7 February 2017

File No: 2017/049179
Your Ref: SSD 7484

RE: Stage 2 DA for tourist and visitor accommodation – The Sandstone Precinct, 23 – 33 & 35 – 39 Bridge Street, Sydney

EB: Farrer Place/G level

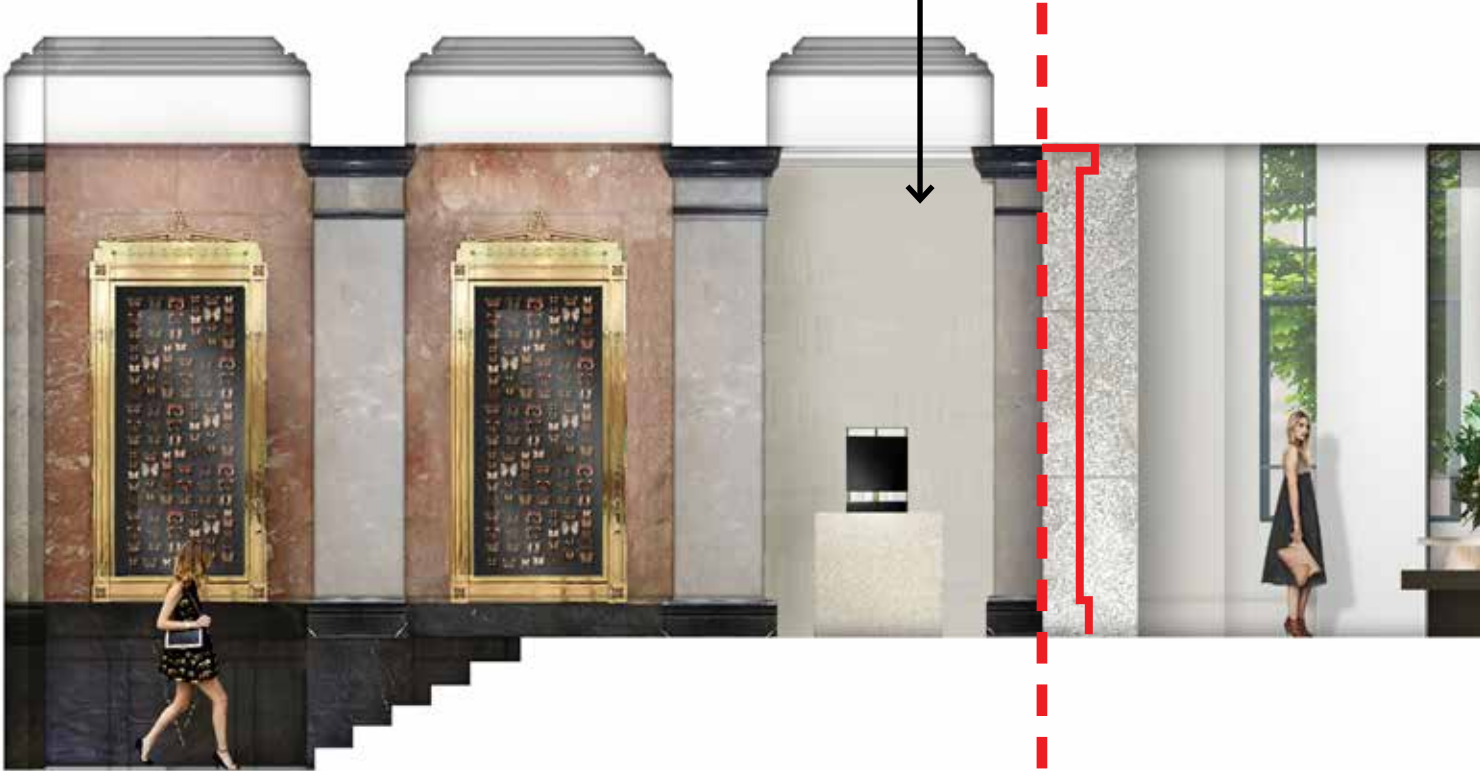
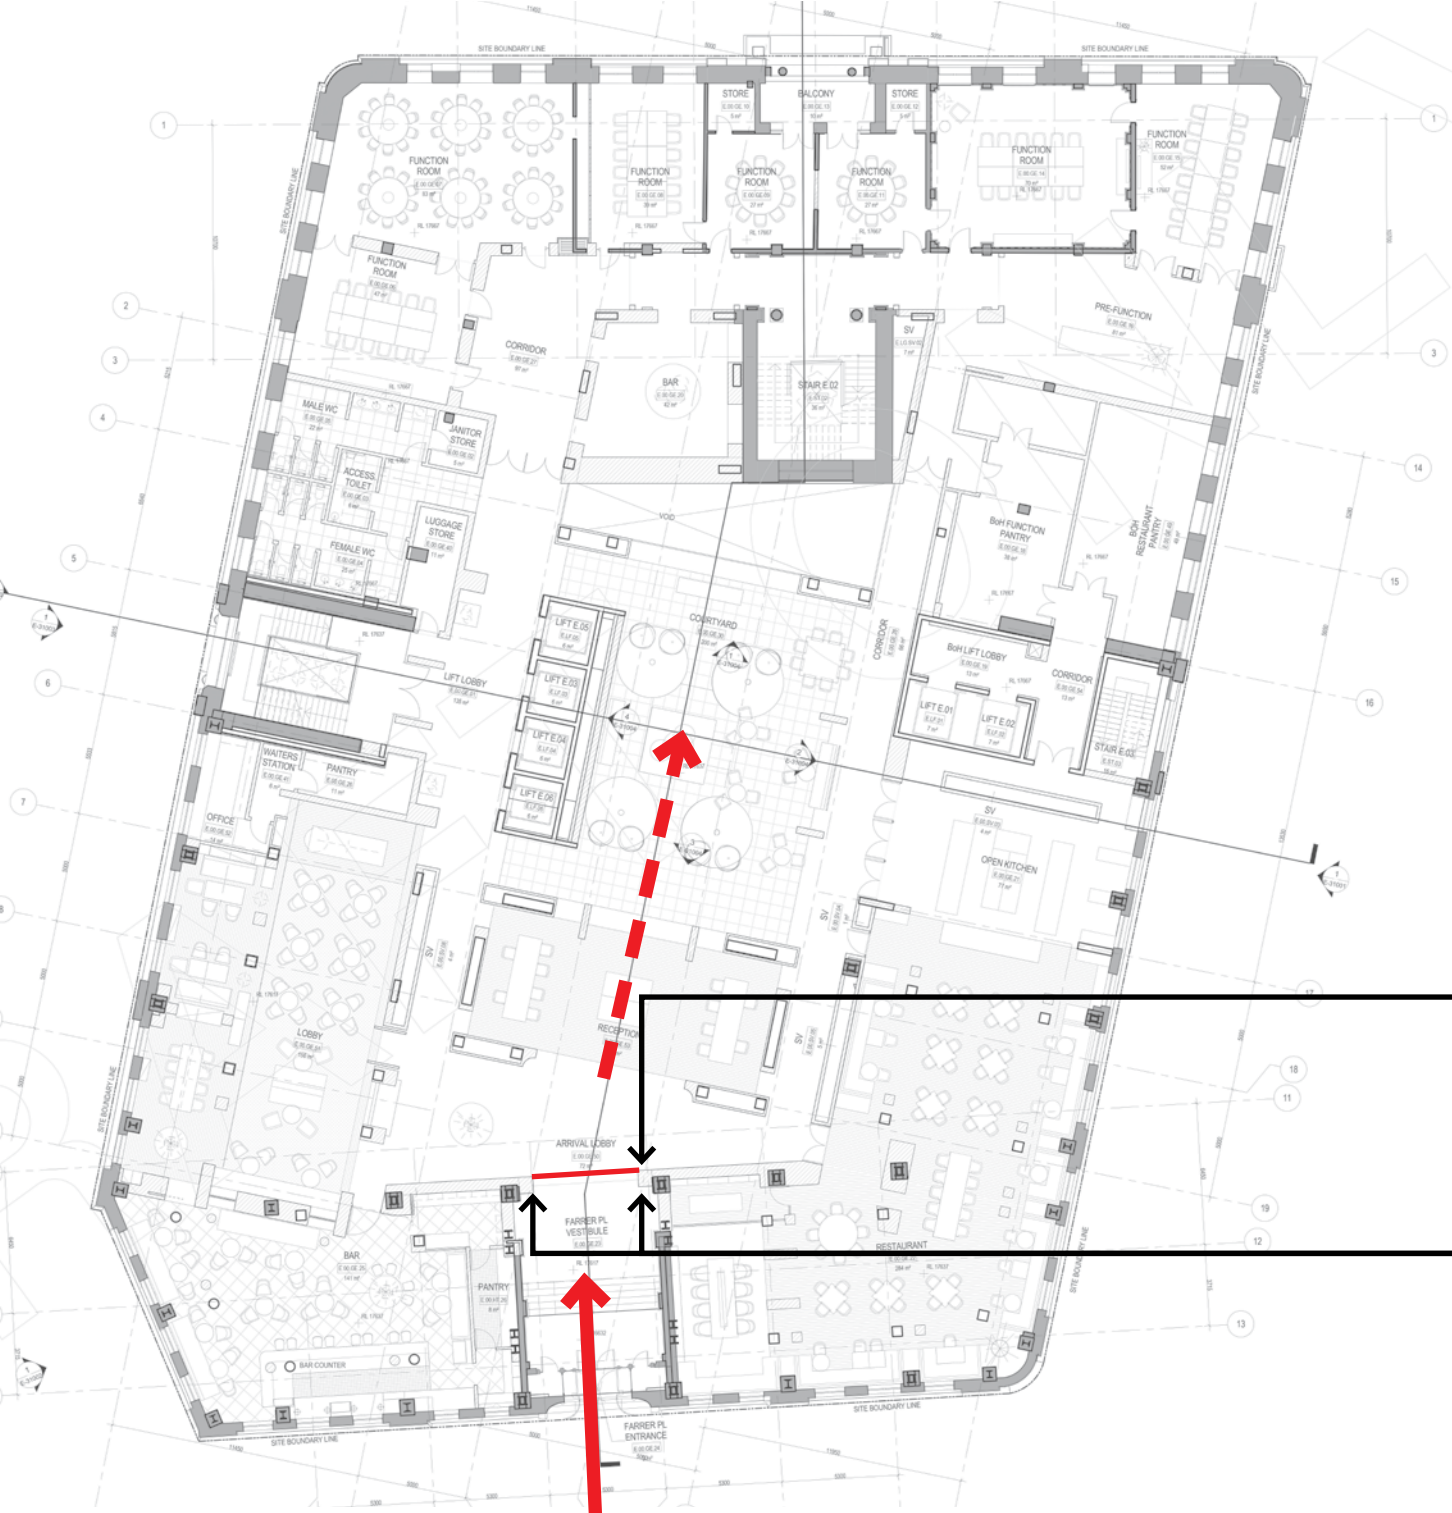
- The northern wall enclosing the Farrer Place entrance lobby, and the corridor extending north from this space, where portions of the original could configuration readily be retained, and
- The eastern wall enclosing the Loftus Street entrance lobby, where portions of the original could configuration readily be retained.

Proposed layout
• overlaid with new works

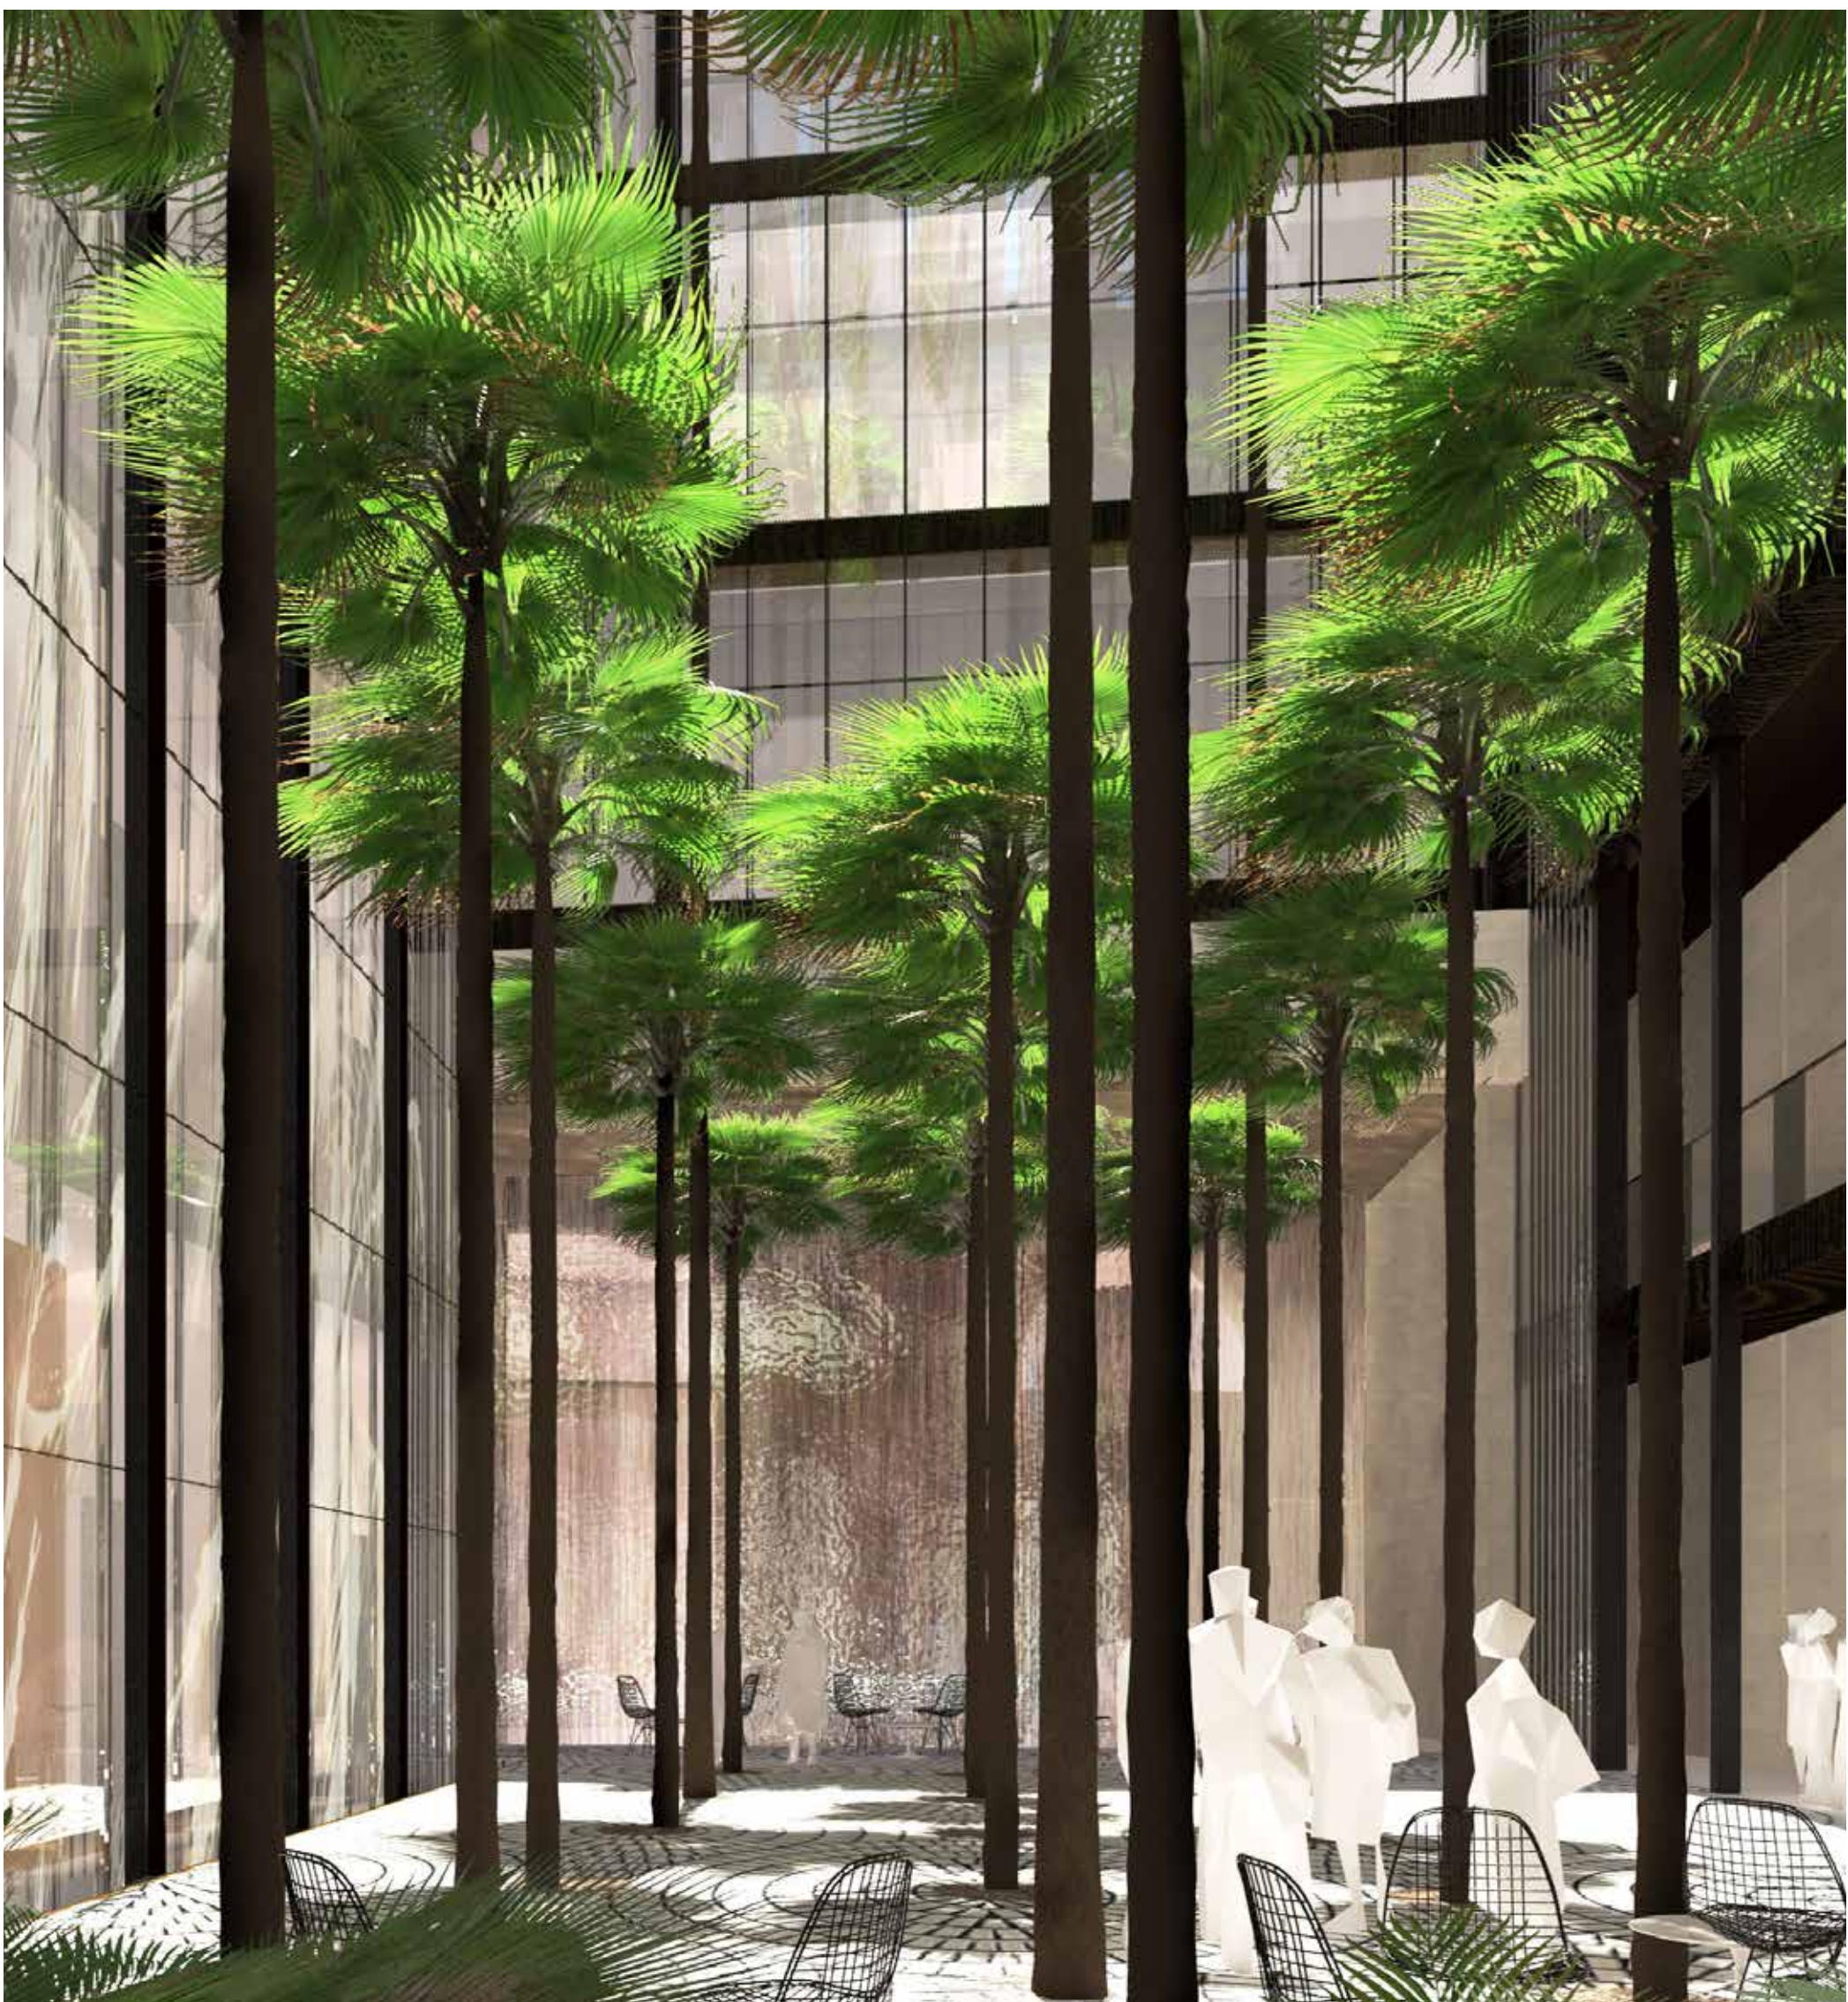
- The proposed reconfiguration of the courtyard, a space that is substantially graded as being of high significance, is not supported. The demolition of all perimeter walls of the 1915 building and the adjustment of the geometry of the entirety of the courtyard from a parallelogram to a rectilinear plan form is an unacceptable level of change. Whilst the geometry of the southern half of the courtyard could be adjusted, the northern half of the courtyard should closely interpret the 1915 geometry. Further, the proposed intrusion into the courtyard of hotel rooms on level 2, and all levels above, diminishes the footprint of the northeastern portion of the courtyard and has the potential to diminish the daylight levels within the courtyard. The overhang of these rooms will also inhibit light levels into the original Bridge Street staircase remaining up to Level 1. This aspect of the proposal requires further assessment based upon daylight studies of the courtyard and stair.
